Appeal Decision

Appeal Ref: APP/R5510/W/21/3271012

1-2 Marlborough Parade, Uxbridge Road, Uxbridge UB10 0LR

- The appeal is made under section 78 of the Town and Country Planning Act 1990 against a failure to give notice within the prescribed period of a decision on an application for planning permission
 - The appeal is made by Erindale Ltd on behalf of SHA Ltd against London Borough of Hillingdon.
 - The application Ref 19108/APP/2020/3815, is dated 18 November 2020.
 - The development proposed is Three storey side extension and two storey rear extension to create a retail unit, 4no. new 2-bed units and with associated amenity, cycle and refuse store.
-

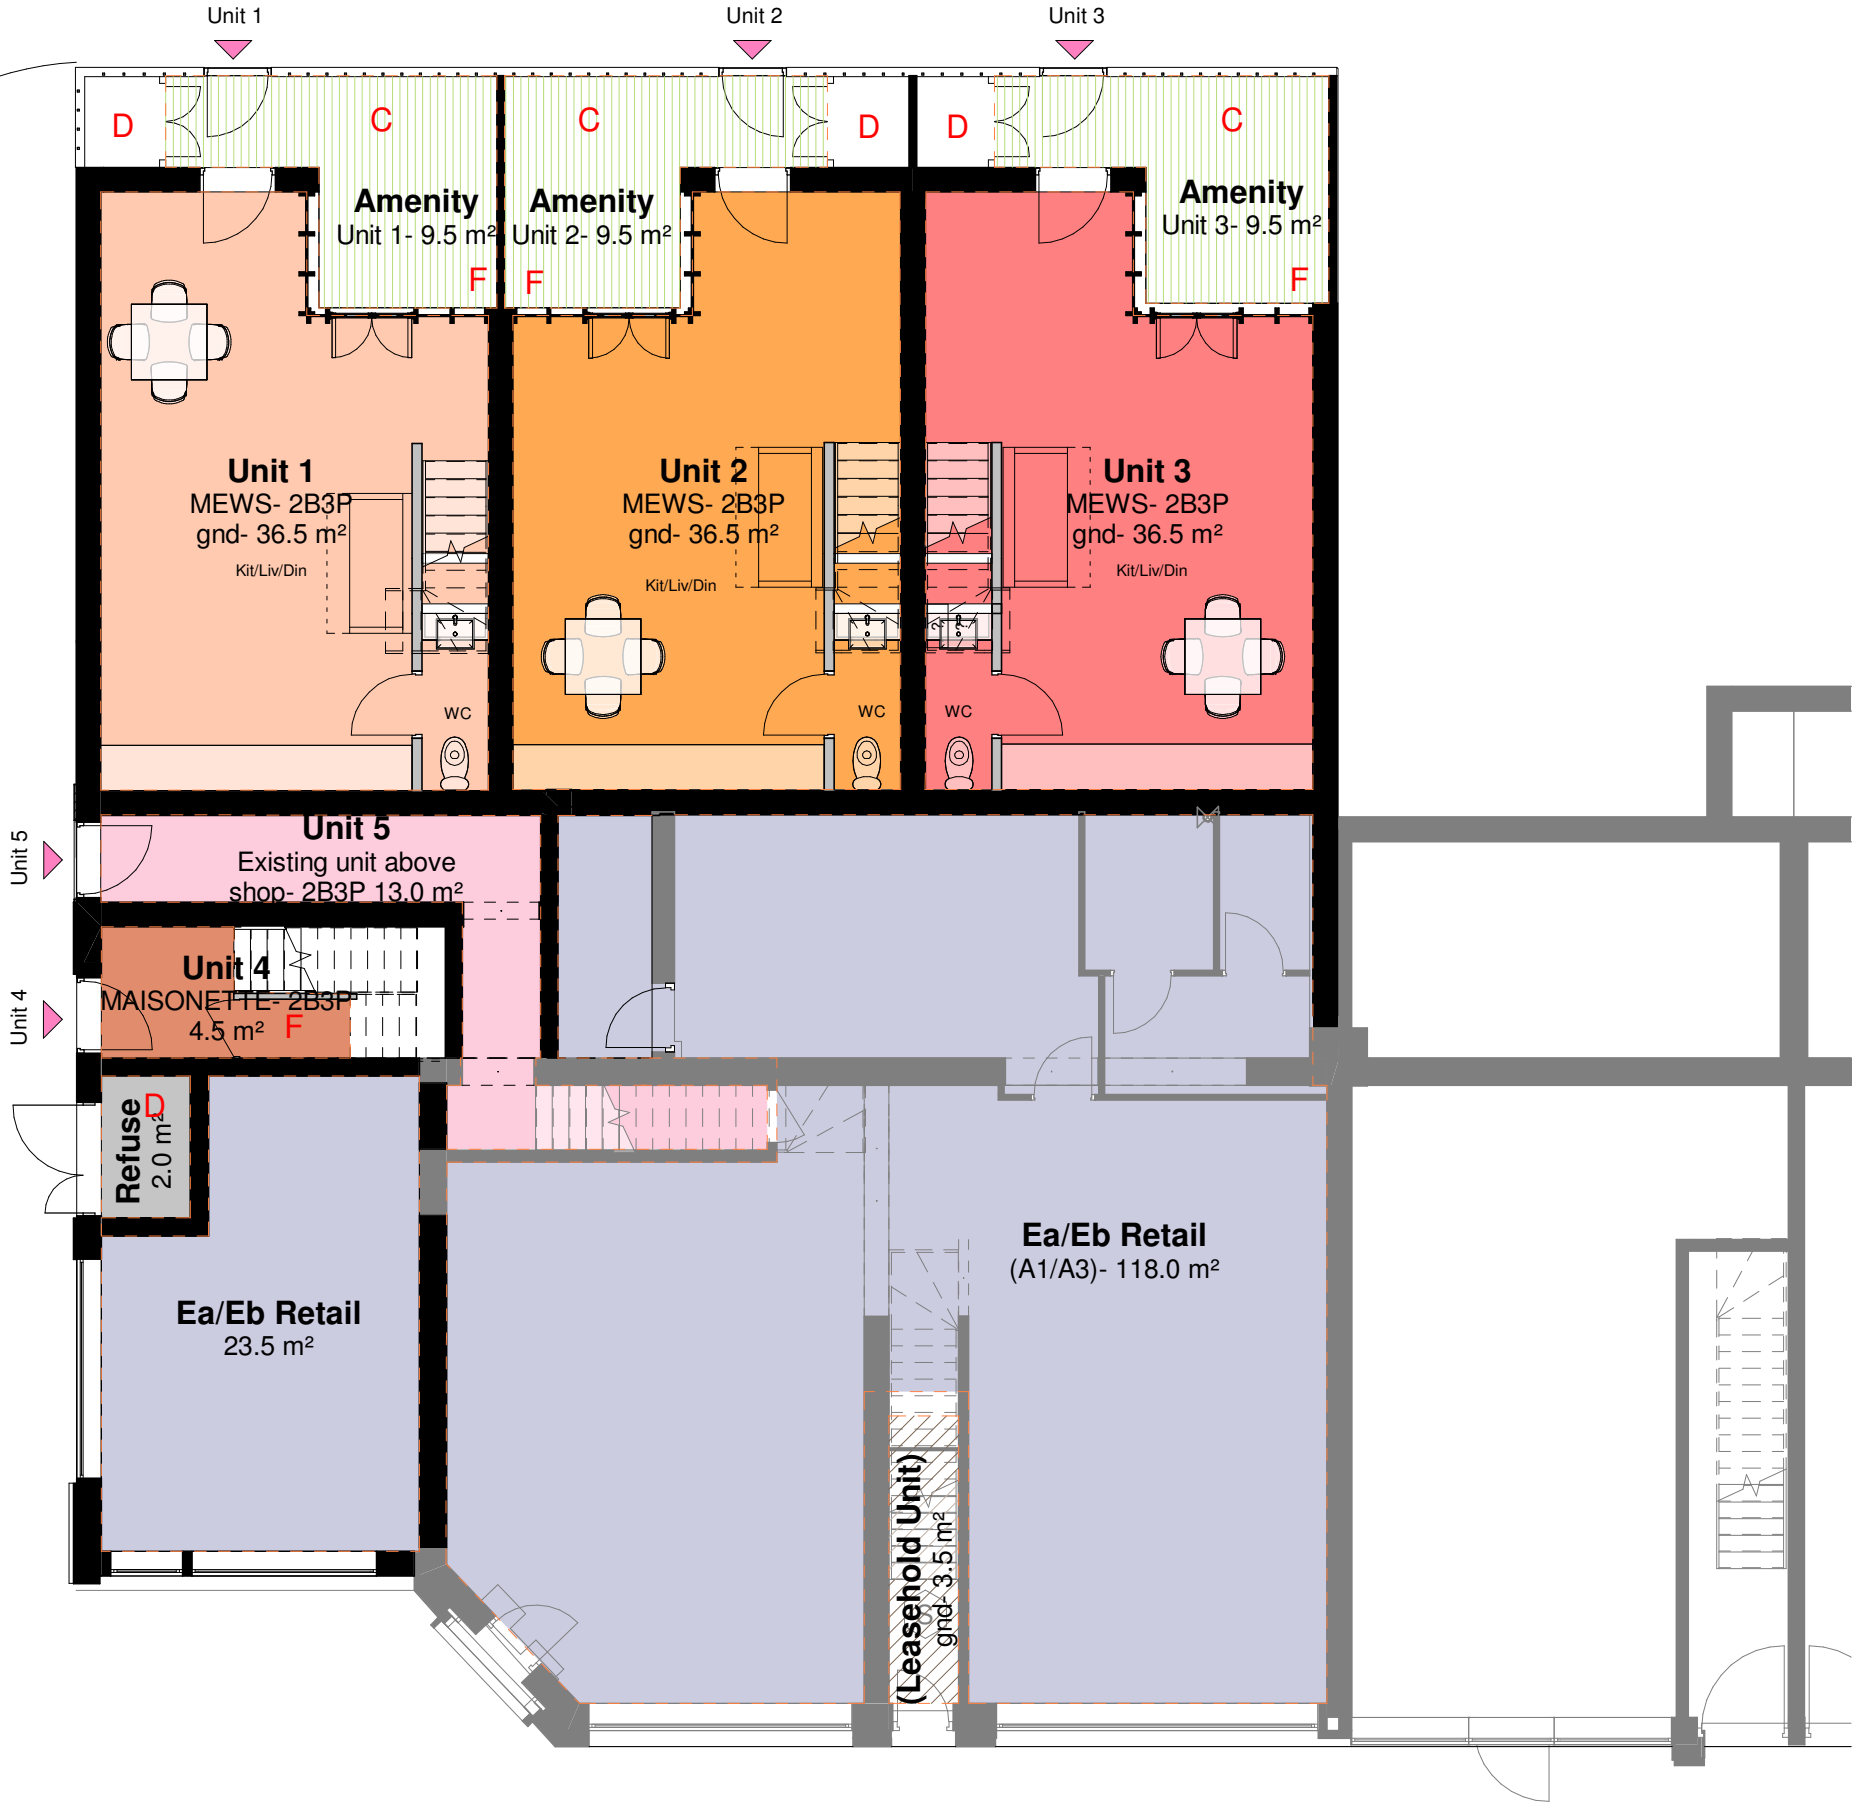
9. Private amenity space would be provided for each of the proposed units. Unit 1 would have a small courtyard to the front of the property, a feature replicated for Units 2 and 3. However, Units 2 and 3 would also have separate amenity space to the rear at first floor level. Unit 4 would have amenity space provided at first and second floor level. In terms of area, only Unit 2 would meet the requirements of local policy, this being 25sqm for two-bedroom flats. Unit 1 would be provided with 9.5sqm which would be located to the front of the property, close to the main road. Accordingly, due to the size and location of this space, I find that it would not enable private enjoyment as required by local policy. This would directly affect its usability and the space would also incorporate access into the flat. Accordingly, in my judgement, the small courtyard would not provide well-located or well-designed private outdoor amenity space.

afforded a greater level of privacy. In addition, a balcony would be provided to the rear of the property. Cumulatively, the flat would be provided with 18sqm of amenity space. However, due to the variety provided within the proposed layout, I find that the arrangement would be usable for the private enjoyment of the occupier.

11. Unit 4 would also be provided with two separate areas of amenity space. However, the space at first floor level would wrap around the internal staircase providing an awkward 'L' shaped space. Due to the limited size of this area, I find that it would not be well-located or well-designed. A small balcony would also be provided at second floor level but due to its limited size, again, in my judgement this would not be a particularly usable space and would not compensate for the awkward layout of the first floor area. Accordingly, I find that the amenity space for Units 1, 3, and 4 would cause demonstrable harm to the living environment that would be provided for future residents.

1/ P2.04 Proposed 1st Floor
1 : 100

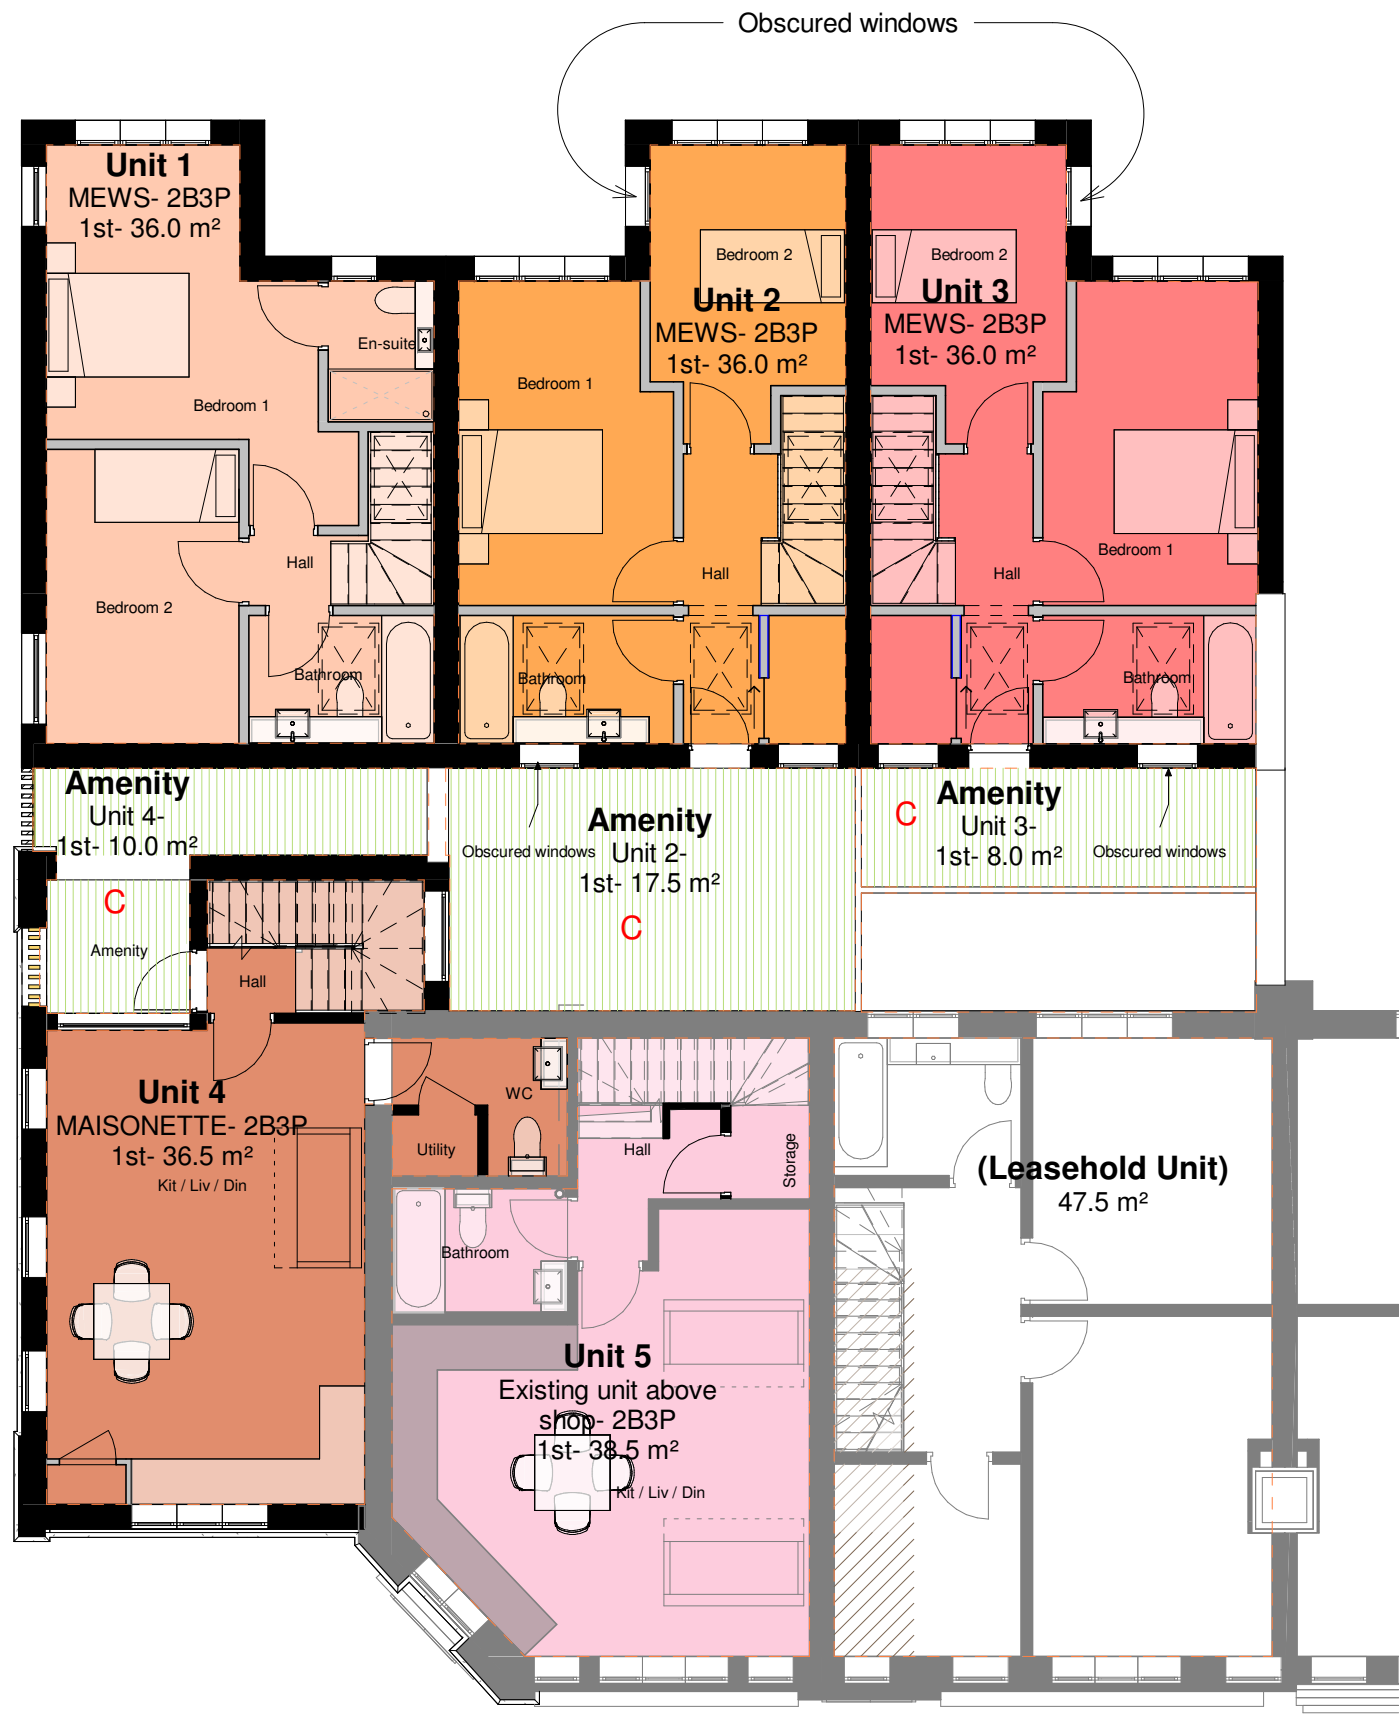
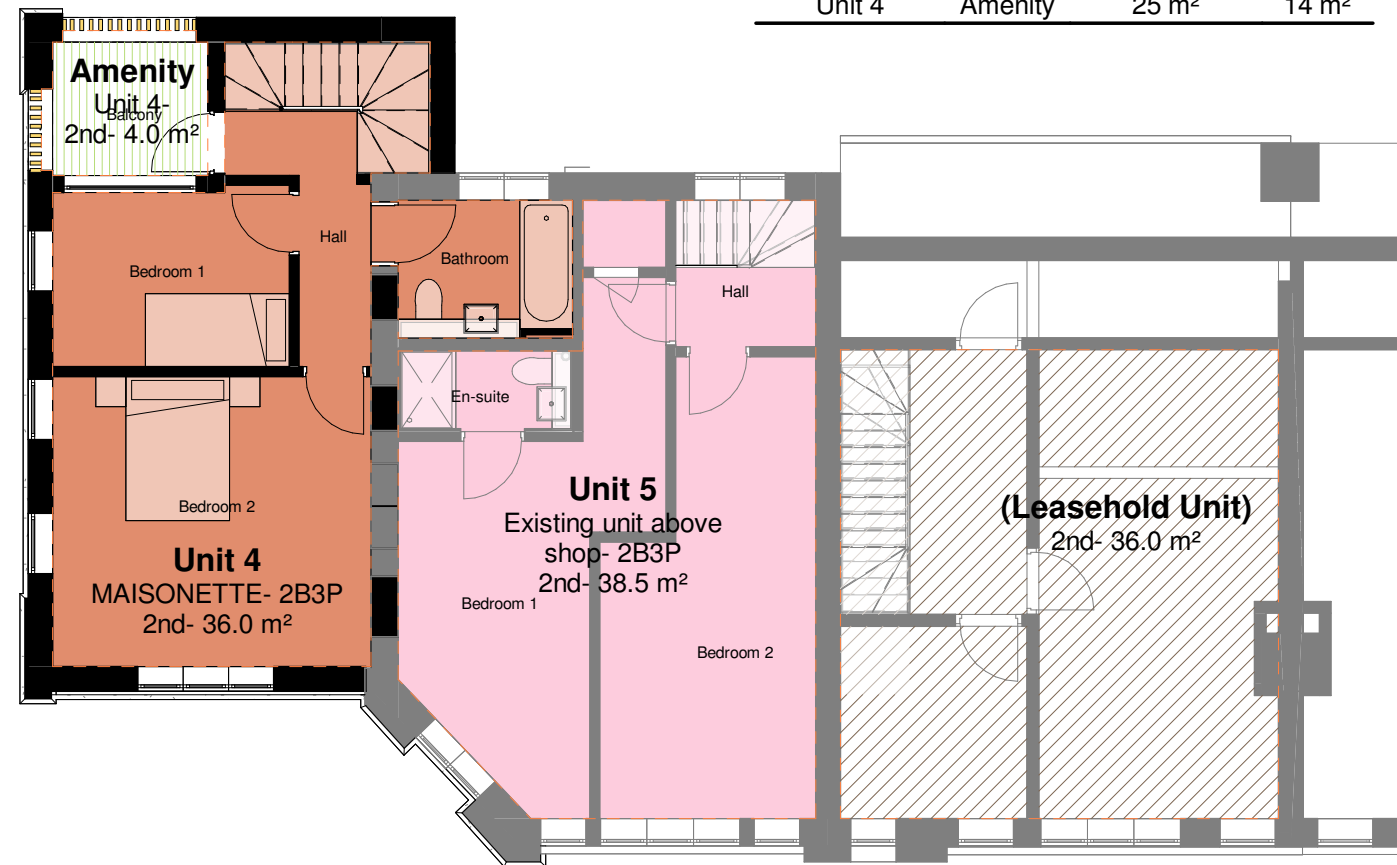
14. Policy D7 of the LP relates to accessible housing and requires dwellings to meet Building Regulation requirement M4(2) 'accessible and adaptable dwellings'. A specific requirement therefore relates to step-free access into dwellings. Based on the evidence before me, Units 1-3 would provide this, but Unit 4, which provides living accommodation at upper floor levels would not meet this requirement. Although step-free access would be provided to a hallway at ground floor level, the actual accommodation provided within the flat could only be accessed via a private stairway.

15. I note the suggestion that units could be retro-fitted to improve accessibility, but the layout of Unit 4 would be such that step-free access to the living accommodation would not be provided. On this basis, I conclude that the proposal would fail to provide accessible housing. It would therefore fail to comply with Policy D7 of the LP, the requirements of which are set out above.

1/ P2.12 Proposed Flank Elevation
1 : 100

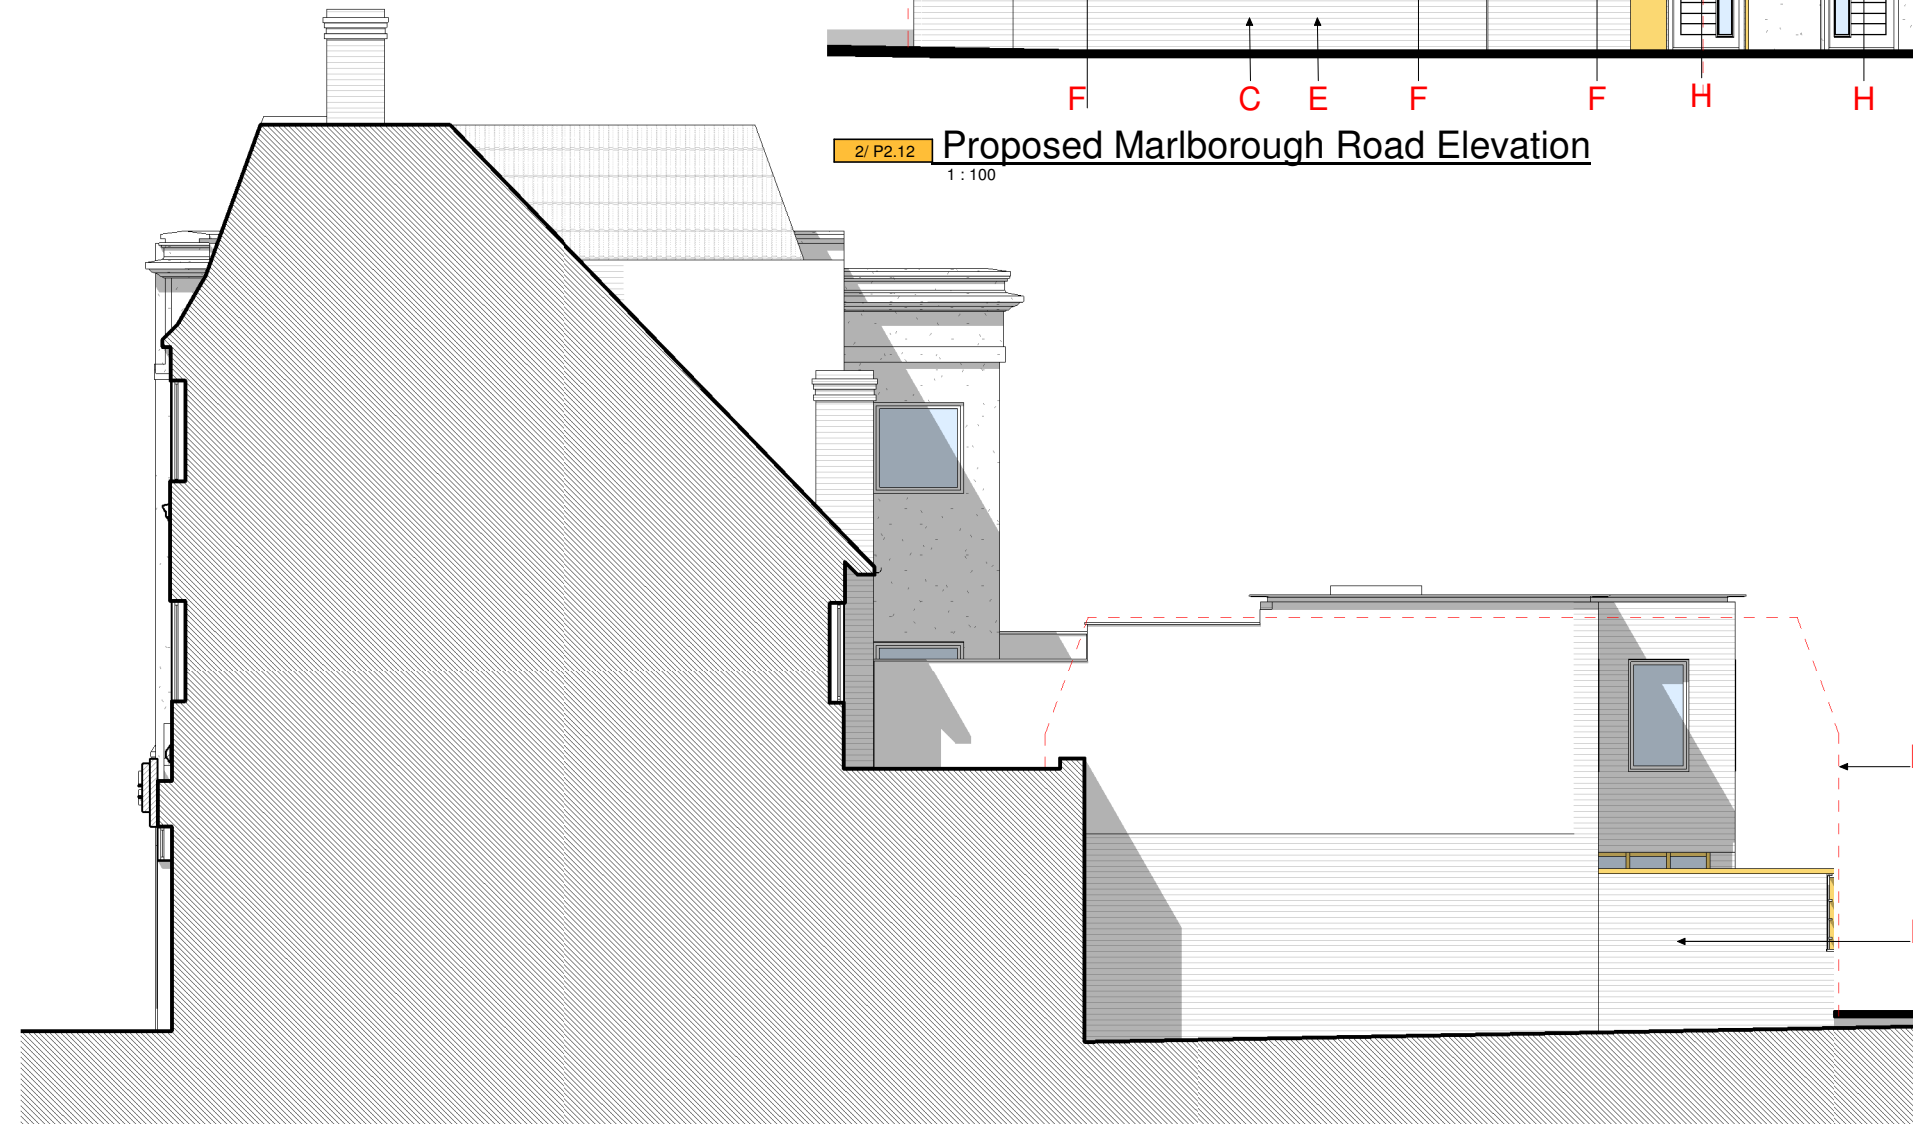
4. The appeal proposal would create four new residential units, three of which would have their principal outlook onto an access drive to the rear of the appeal site. The driveway is also bounded by the flank elevation of No. 2 Marlborough Road and due to its set back from the road, this elevation would be opposite units 2 and 3 of the proposal.

6. As a consequence of these revisions to the proposal, the appellant confirms that the separation distance between facing windows and the side elevation of No 2 would be 5.15m as a minimum and 7m as a maximum. This would provide a greater separation distance to that previously proposed. However, within the previously dismissed appeal, concern was raised regarding the *'very poor levels of outlook...which would create a harmful and oppressive sense of enclosure to future occupiers.'*

7. Despite the revisions, the side elevation of No 2 would remain as a tall and deep structure, located in close proximity to the proposed dwellings. Although the proposal would increase the separation, this would only be in a modest manner. Accordingly, the level of separation would remain limited and as a consequence, the side elevation would continue to represent a dominant and imposing structure that would substantially impact upon outlook. As identified above, the previous decision identified that levels of outlook would be 'very poor', and despite the alterations to the proposal, I am also of the view that outlook would be demonstrably poor and unacceptably dominated by the adjacent building. Accordingly, due to the location of the proposed facing windows, the flank elevation of No 2 would still provide a harmful and oppressive sense of enclosure to future occupants.
